**A57 LINK ROADS TR010034****RESPONSE TO PD-014 - REPORT ON IMPLICATIONS FOR EUROPEAN SITES****CPRE Peak District and South Yorkshire  
Unique Reference: 20029243****DEADLINE 9 – 27 April 2022**

Insert 2 High Peak AADT Flow 2025

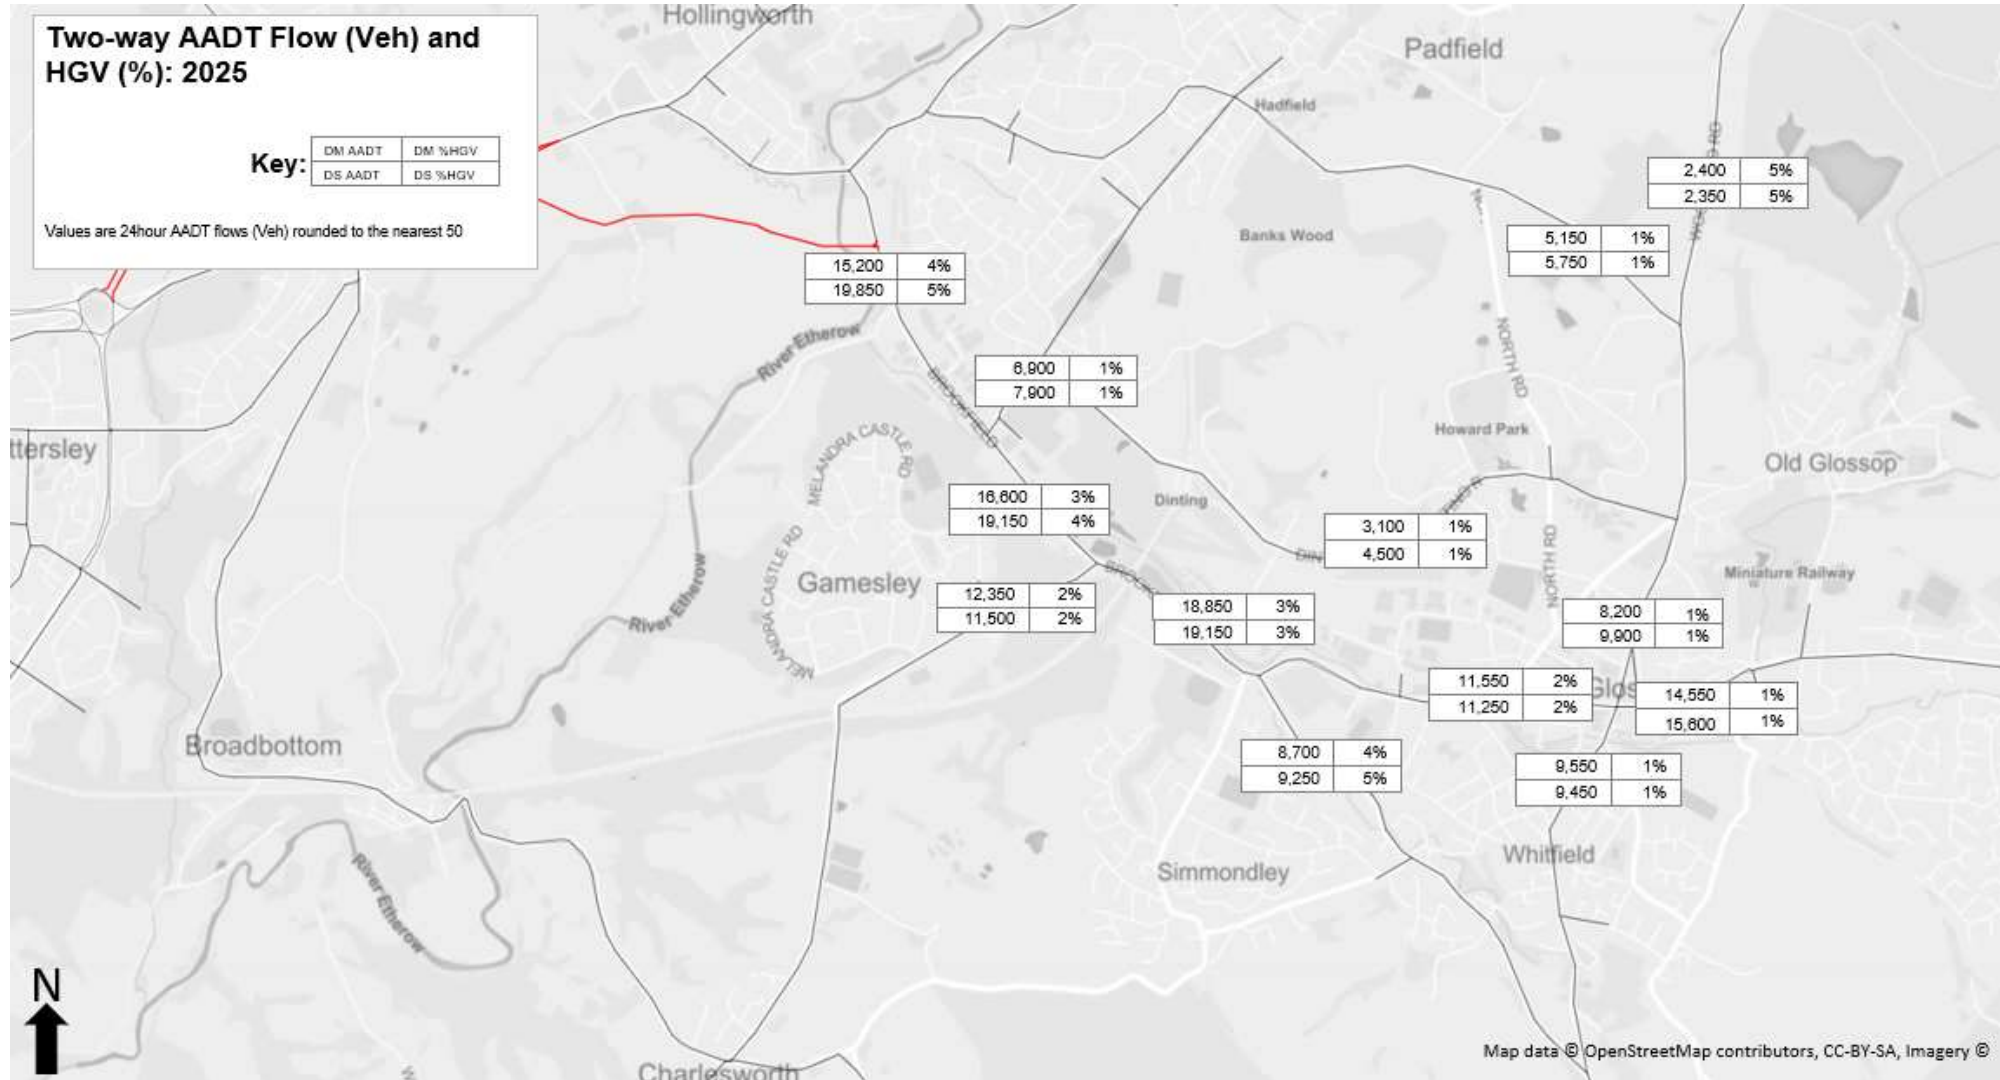
The traffic flows on Market Street through Hollingworth are given as 15,900 AADT in DM 2025<sup>6</sup>. The traffic flows through Tintwistle are given as 9,699 AADT DM<sup>7</sup>. NH makes it clear the latter are flows through the Tintwistle AQMA which is on the eastern edge of the village and well to the east of New Road. NH explains the enormous difference in flows - 6,000 AADT - between the two villages in this way:

*The traffic flows on the A57 Glossop High Street East and A628 Market Street are higher than the traffic flows on the sections of these roads through the Peak District National Park (PDNP) because of the additional traffic demand generated within the urban areas of Glossop, Hollingworth, Tintwistle and Hadfield. This additional traffic demand is predominantly for journeys to and from destinations to the west, rather than across the PDNP and, therefore, results in significantly high flows on these sections of road compared to the sections of road through the PDNP.*

So the drop in flows of 6,000 AADT between Hollingworth and Tintwistle has to be explained by traffic leaving the A628T and filtering into the Tintwistle side streets and/or using New Road as the rat run for Hadfield/Padfield villages to get to the A628T Market Street (there is no other route through Tintwistle to serve as a suitable rat run).

The population of Tintwistle is only 1,400 and therefore most unlikely to account for 6,000 daily vehicle movements; some must be accounted for rat running to/from Hadfield/Padfield. If this is the case we would expect flows on New Road to reflect this. On New Road NH has modelled 800 AADT in 2025 DM and 1,200 AADT in 2025 DS ie a change of 400 AADT; so despite what NH say about Hadfield/Padfield/Glossop residents rat running to the A628T to head west they are not using New Road in significant numbers, either with or without the scheme. Mr Bagshaw's evidence also supports this deduction [REP4-027].

If, in its explanation above, NH is referring to the current situation and everyone in Tintwistle who is able to drive (say 1,000 people) was contributing to the 6,000 lost flows then every single person is making six trips a day (nationally the average is 1.6 trips per day<sup>8</sup>); if NH is referring to the situation with the scheme in place then the scheme creates demand for 6,000 more trips from Tintwistle. Neither result is credible.

It appears likely that the 6,000 vehicle movements are still on the A628T, about half may disappear into Tintwistle but where do the rest go? Tintwistle was one of the air pollution sites which would have jeopardised the DCO and for which the model was refined. In REP2-069 4.2.7-4.2.10 we drew attention to the inconsistencies between the trend in DfT counts and 2025 DM modelled flows on the A628T east of Tintwistle. Clearly there is uncertainty about modelled traffic flows on the A628T, which means the screening out of the European sites alongside the A628 (and the Tintwistle AQMA) is highly questionable.
